From: Samantha May [REDACTED]
Sent: 08 June 2021 23:51
To: Planning <Planning@arun.gov.uk>
Subject: Application_Ref_No=R/113/21/PL

I am very concerned about the impact the above application would have on my [REDACTED] elderly mother, and her fellow occupants of Pegasus Court. Pegasus Court is directly north of the proposed building and comprises 30+ retirement flats. The majority of the occupants are elderly and have various health and mobility challenges. I therefore wish to register an objection to the application due to foreseeable negative impacts outlined as follows:

FIRST FLOOR PLAN

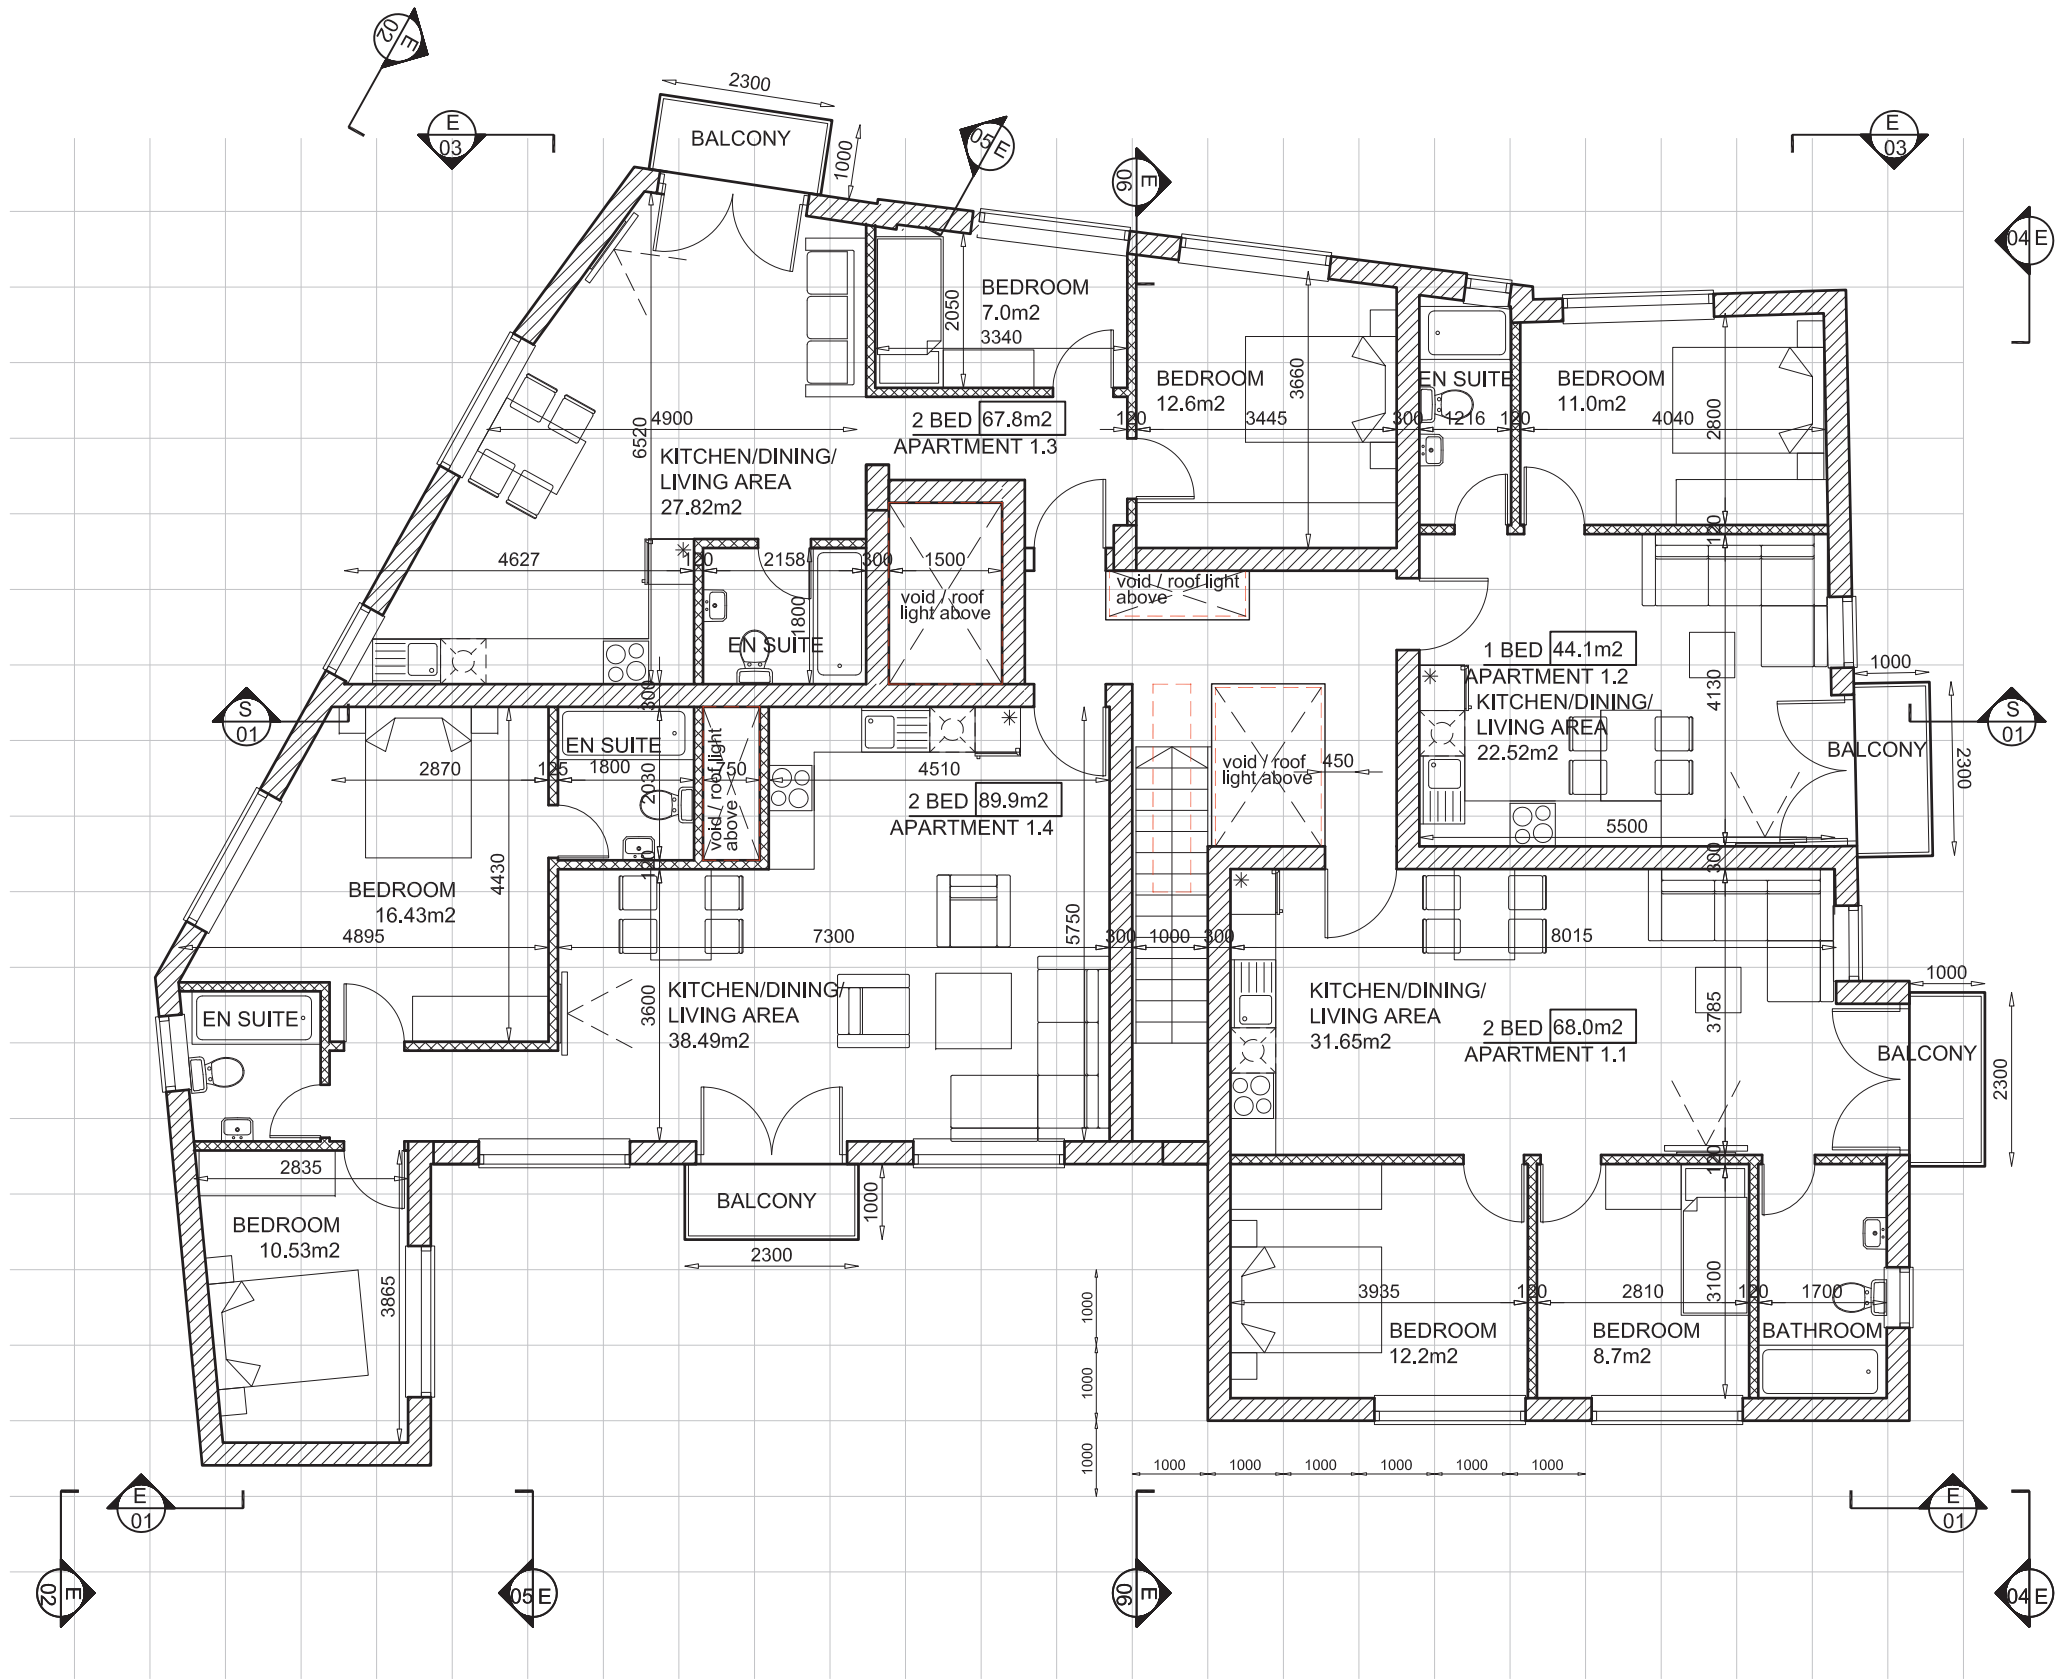
1. Reduction in light entering the south facing west block ground floor flats - detrimental to all occupants, and may reduce my mother's ability to live independently as being [REDACTED] she needs high light levels.
2. Invasion of privacy for all flats in the south facing west block, due to overlooking windows and balcony in the proposed plans. Installation of nets or other barriers to protect their privacy would be an unreasonable compromise given the need for high light levels for some occupants.

GROUND FLOOR PLAN

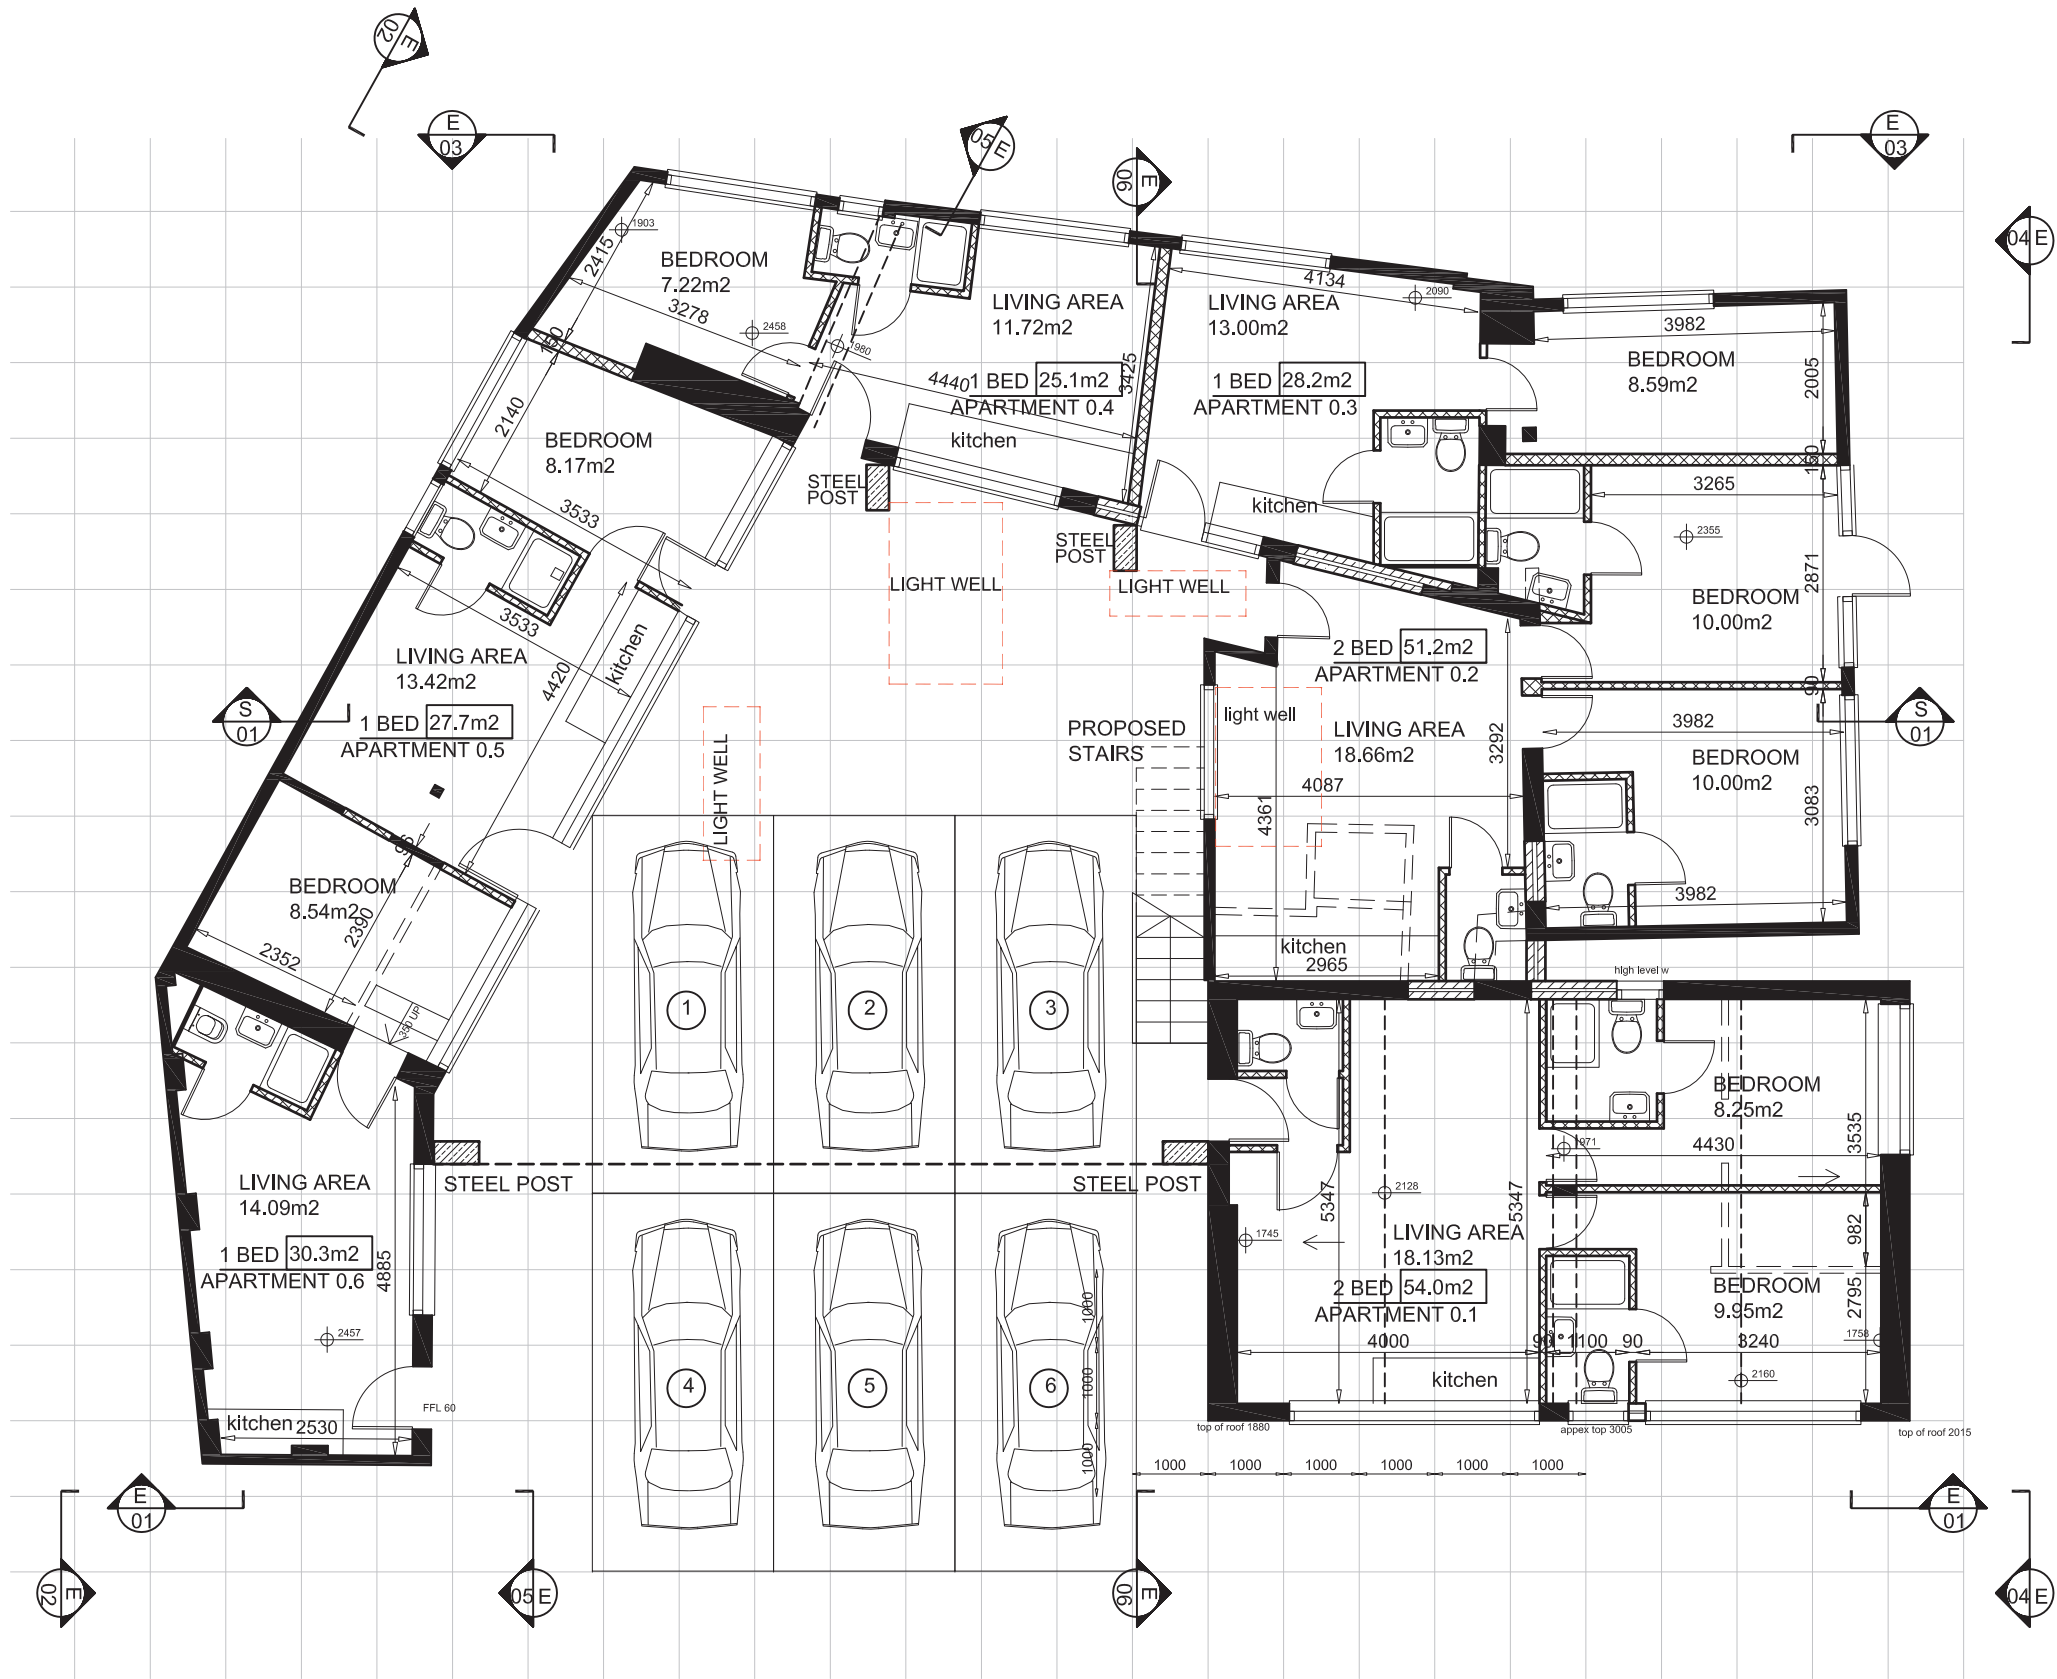
4. The plan shows parking for 6 cars but that looks unrealistic with 3 having no way of getting around the other 3. With a combined total of 10 flats it is therefore inevitable that parking needs will overflow into other areas of the local community which doesn't seem fair.
